Manston Airport DCO: Comments on responses to the Examining Authority's First List of Questions - Historic Environment

# RAMSGATE CONSERVATION AREA

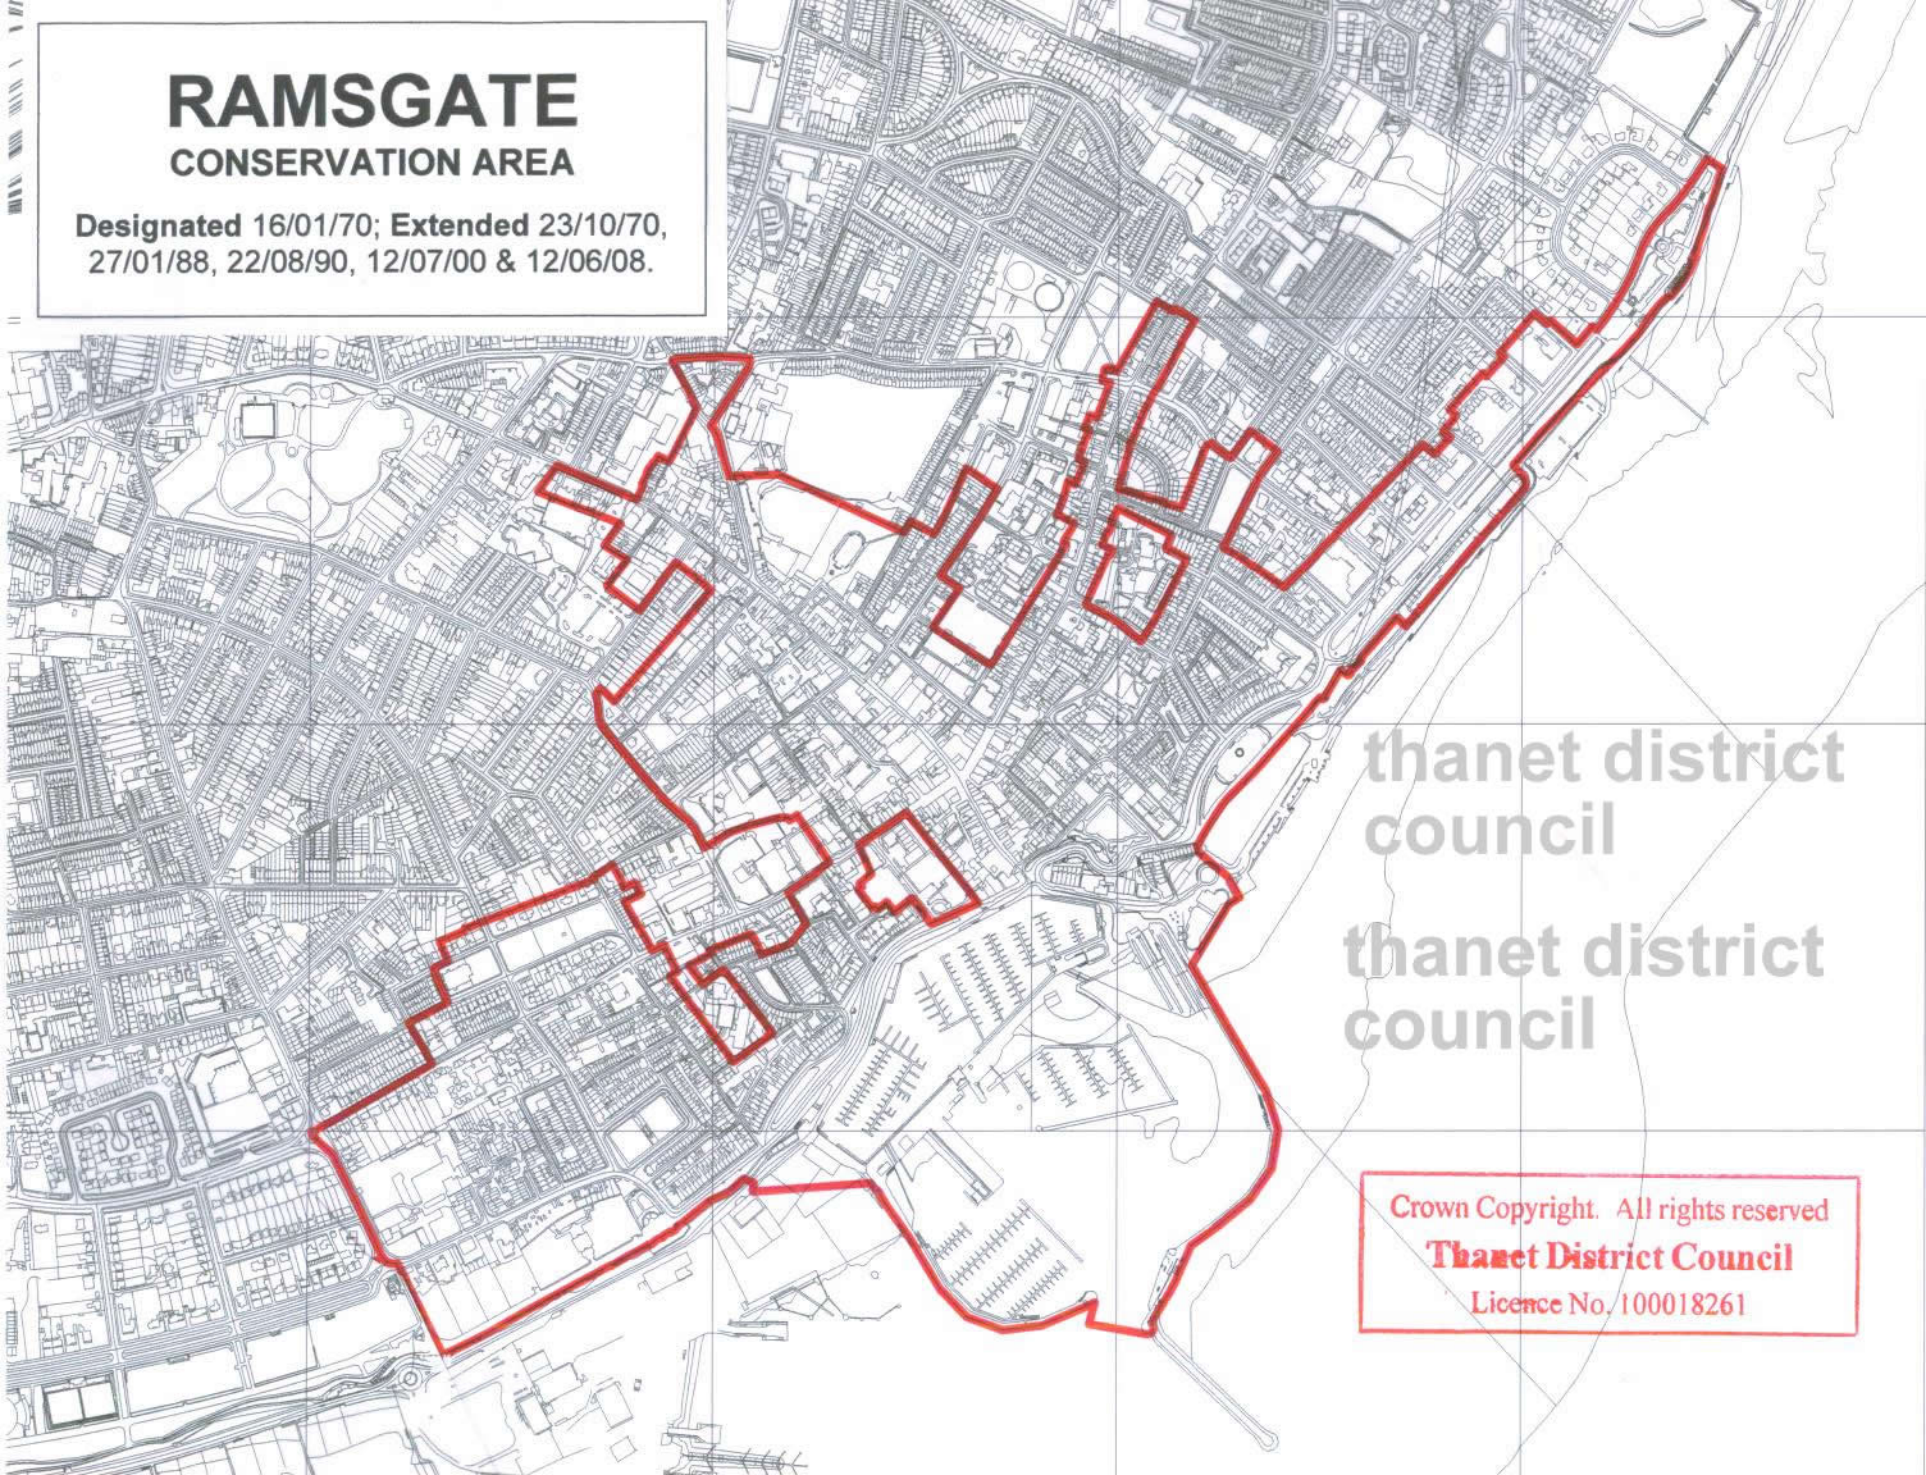
Ref	Question	Response	Comments
HE.1.4	<p>Conservation Areas</p> <p>Paragraph 9.6.18 of the ES, Volume 1, Chapter 9 [APP-033] identifies Ramsgate Conservation Area as potentially subject to significant adverse indirect effects. However, Table 9.15: Assessment of effects arising through change to setting of designated heritage assets, does not include an assessment for Ramsgate Conservation Area.</p> <p>Q: Detail the effects that you consider the proposed scheme would have on the character and appearance of the Ramsgate conservation area</p>	<p>Applicants' Response:</p> <p>An initial scoping appraisal of the potential effects of the Proposed Development on the significance of the Ramsgate Conservation Area is set out at Table 5.1 and Table E.3 of Appendix 9.1 of the ES (APP-051). Table 5.1 noted with regard to visual effects that 'Visibility between all of these conservation areas and the airfield is obscured by topography, vegetation and the built environment... As settlements, they produce light pollution. This is greater in the larger settlements of Ramsgate and Broadstairs. Changes to the proposed site should have no effect on the setting of these assets'.</p> <p>Table E.3, considering the effects of aviation noise noted that 'Ramsgate conservation area comprises the historic core of a busy resort and port town. In the majority of the area, the existing soundscape is provided largely by traffic noise with occasional noise from harbour and marina operations, which reinforce the area's historic and functional links with the sea.</p> <p>The majority of this area is not sensitive to altered levels of background noise, and the noise relating to port operations would not be affected by the relatively low noise levels predicted. Consequently, aviation noise is not considered likely to give rise to any perceptual change in the setting of the area and no adverse effects are anticipated.'</p>	<p>Ramsgate Society and RHDF:</p> <p>The issue of visual effects has nothing to do with the appearance of the airport site which, as stated, is not visible from the Ramsgate Conservation Area. Rather, it is crucially about the impact of low flying aircraft, landing and taking off from the airport, given the direction of the eastern flight path which cuts a swathe across the conservation area. In this respect there is clearly a significant negative visual impact given the proximity of the airport to the conservation area and the intensity of ATMs forecast at Year 20.</p> <p>There is doubt, as we explain in our comments on HE'S Written Representation, as to whether the noise matrix utilised by the applicant has been correctly applied given Manston airport is and has been unused for aviation purposes for 5 years. That aside the applicants' statement is unsupported when account is taken of the consultants' overall conclusion on noise, viz:</p> <p><i>In these communities (Ramsgate..), aircraft noise would increase to the point where there would be a perceived change in quality of life for occupants of buildings in these communities or a perceived change in the acoustic character of shared open spaces within these communities (Para 4.1.47 Volume 5 Non-Technical Summary TR020002/APP/5.1)</i></p> <p>In our opinion the applicants response is completely disingenuous and we ask the Ex A to allow The Society and RHDF to address the panel in order to give an assessment of the damage which would ensue to the character and appearance of the Ramsgate Conservation Area.</p>
